re: Geotechnical Response to City Comments
Proposed Residential Building
2458 Cleroux Crescent - Ottawa

to: HP Urban Inc. – **Peter Hume** – Peter.Hume@hpurban.ca

date: June 12, 2026

file: PG5973-MEMO.04

2458 CLEROUX CRESCENT: ROOF STORMWATER STORAGE PLAN

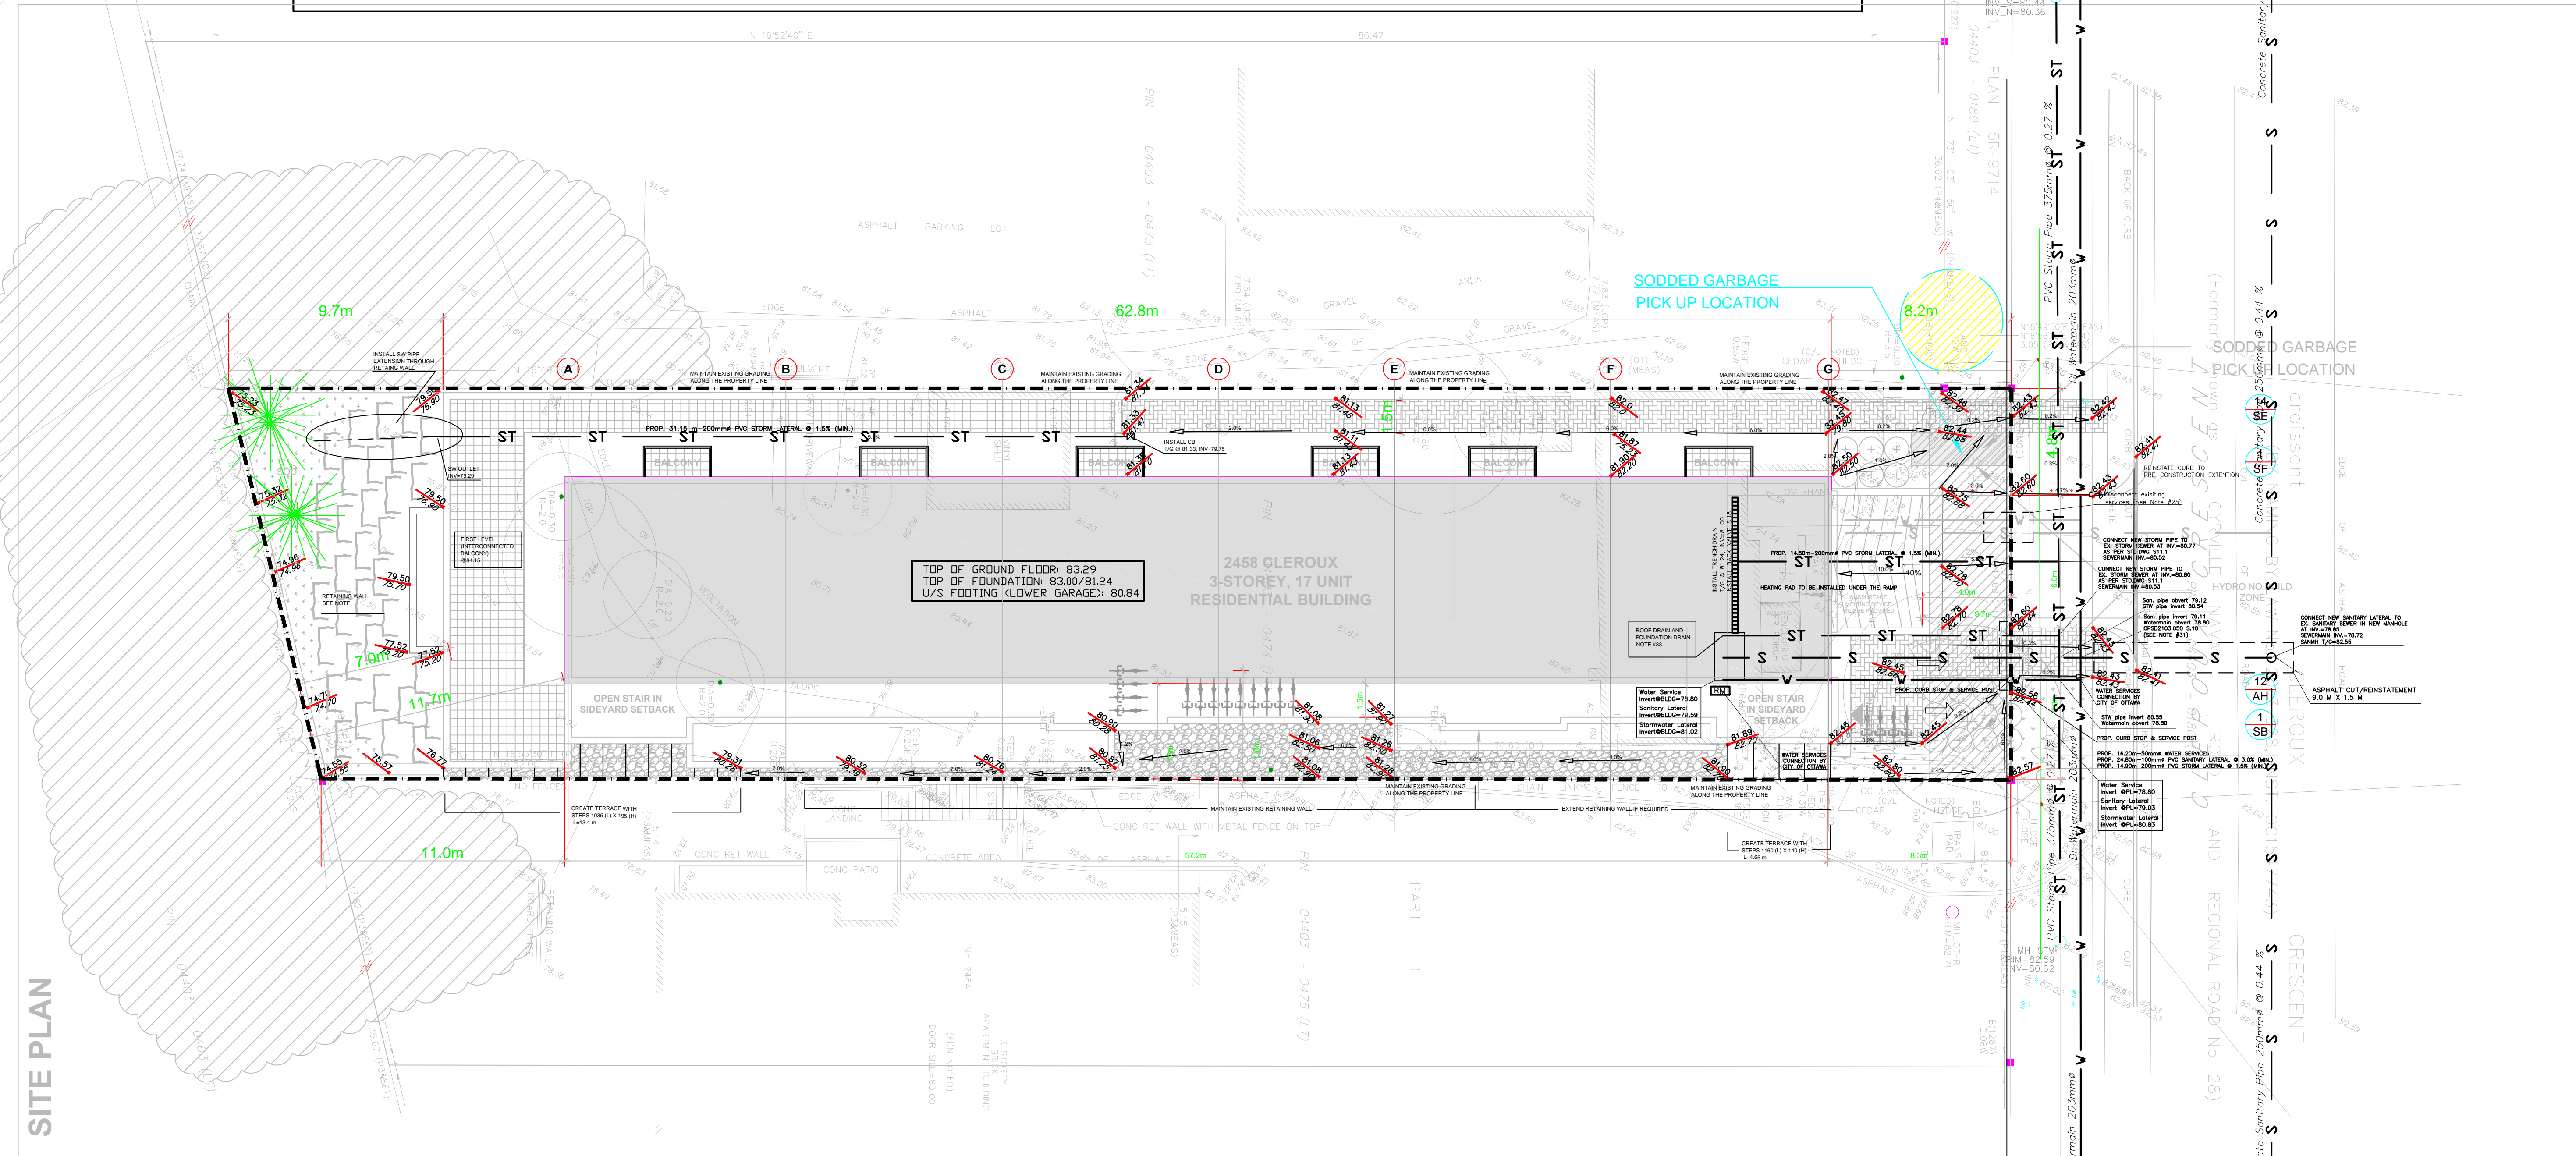
Comment 32: *Retaining wall in rear yard designed by structural engineer in accordance to Geotechnical Report, Paterson PG5973 Revision 1 (April 2022) and PG5973-MEMO.01. Contractor to implement prescribed measures and report to engineer for concurrence.*

Response: Based on discussions with the project team, the proposed retaining wall will be substituted by grading accomplished through the earthworks program. The currently proposed grading (referring to *Services & Grading Plan*, Plan No: 18880 dated April 2026 and prepared by Arch-Nova Design Inc.) provides top of wall grades ranging between 77.52 and 76.77 m which tie into the existing ground surface at the property line located near the bottom of the wall.

The proposed grading may be accomplished through the placement of site-generated workable brown silty clay fill placed in maximum 225 mm thick loose lifts and compacted in lifts using a suitably-sized vibratory sheepsfoot roller to a minimum of 95% of the materials SPMDD. The site-generated material may not consist of grey clay or other lesser workable soils. It may consist of imported material, however, should not consist of crushed stone fill due to grade raise restrictions. The previously recommended lightweight fill recommendation will remain applicable for this portion of the subject site and for during the backfilling stage.

It is expected grading along the rear of the structure using this methodology will reach up to a steepness of up to 1.5H:1V (near the balcony extension reaching an elevation of 79.50 m) and will otherwise be in the range of 2H:1V. It is recommended that the final grades established across the fill layer be established by the placement of a minimum 150 mm thick layer of topsoil blended with either hardy grass or hydroseeding. Establishing root growth from the topsoil layer is important to ensure it remains permanently able to withstand precipitation and snowmelt given the localized steeper inclinations over the long-term.

Grading along the property lines abutting to neighboring parcels along Cleroux Crescent should match the existing grades and be sloped downwards thereafter to match the existing property line at the base of the slope and at the rear of the property. Based on these recommendations, grading will mostly match existing conditions such that the results from the slope stability provided in the geotechnical report remain valid from a global stability perspective. Grading matching the design conditions provided herein are considered stable and acceptable from a global stability and geotechnical perspective and in accordance with the assessment undertaken in the aforementioned Geotechnical Report.
